RE: ALAMEDA BUSINESS PARK LOT 44 (C-16/D6S)  
(8528 Calle Alameda NE)  
ENGINEERS CERTIFICATION FOR CERTIFICATE OF OCCUPANCY  
ENGINEERS STAMP DATED 9/17/2001  
ENGINEERS CERTIFICATION DATED 1/17/2002

**RE: Grading and Drainage Plan for Geotest Inc. (C16-D6S) Dated September 17, 2001**

**RE: Grading and Drainage Plan for Geotest Inc. (C16-D6S) Dated September 17, 2001**

**RE: Grading and Drainage Plan for Geotest Inc. (C16-D6S) Dated June 22, 2001**

GEO-TEST, INC.
LOT 44, ALAMEDA BUSINESS PARK
ALBUQUERQUE, NEW MEXICO
GRADING AND DRAINAGE PLAN

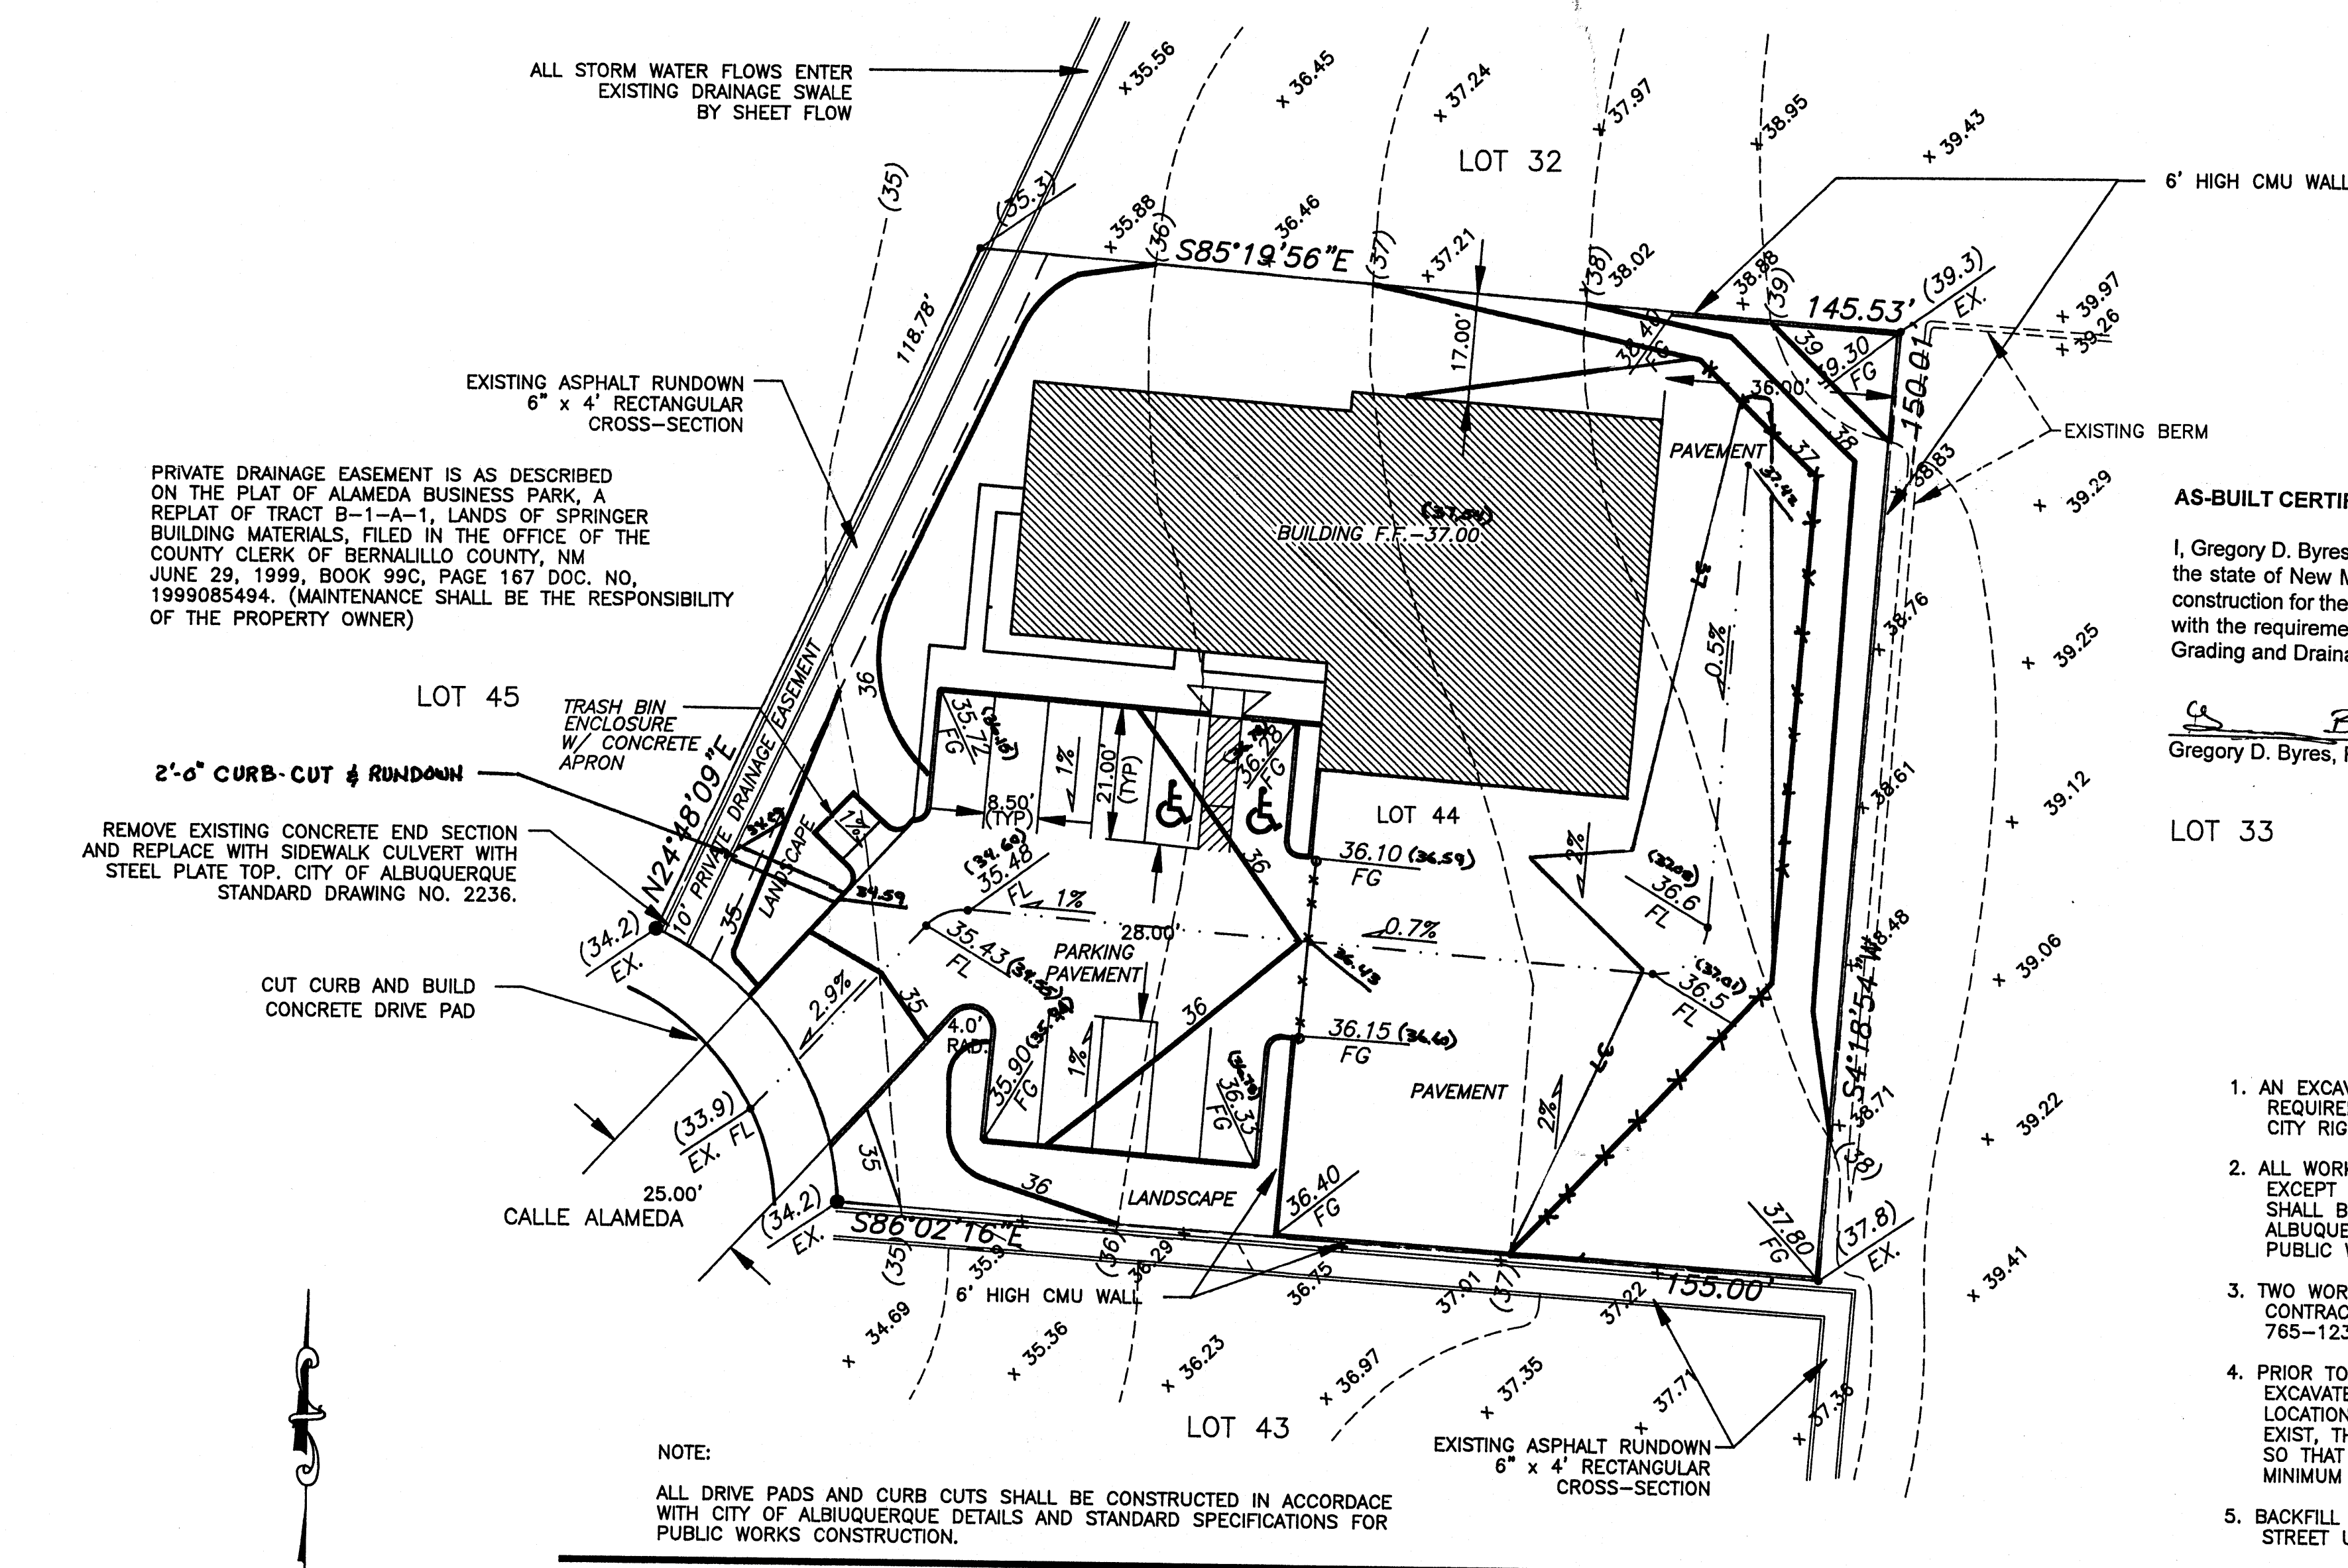
These issues include the City's Storm Drainage Maintenance Inspectors approval signature on the SO19 for the sidewalk culvert; The Engineers Certification should be on the grading and drainage plan which was approved for building permit;

The above referenced drainage plan is approved for Building Permit and SO #19. Changes were made when you submitted the plan for review. The changes indicated that you wanted a 24-inch sidewalk culvert and a 10-foot plate length. Please check these items prior to construction and request for Certificate of Occupancy.

I have reviewed the referenced drainage plan received September 19, 2001 and forward the following comment. When you added the sidewalk culvert in the public right-of-way you need to add certain notes to the plan, obtain an excavation permit, and obtain inspection of the sidewalk culvert by Arroyo Maintenance. I have attached the procedure and the notes to be attached to the plans.

1. Please submit the private easement across lot 44. Who will be responsible to maintain the private easement?
2. Please give more detail on how the runoff from the easement will enter the street. Will there be a sidewalk culvert?
3. Please give more details on how the runoff from lot 32 will enter lot 44. Will there be a fence at this location?
4. Please show existing elevations next to the 6-foot CMU wall on lot 33 and lot 32.
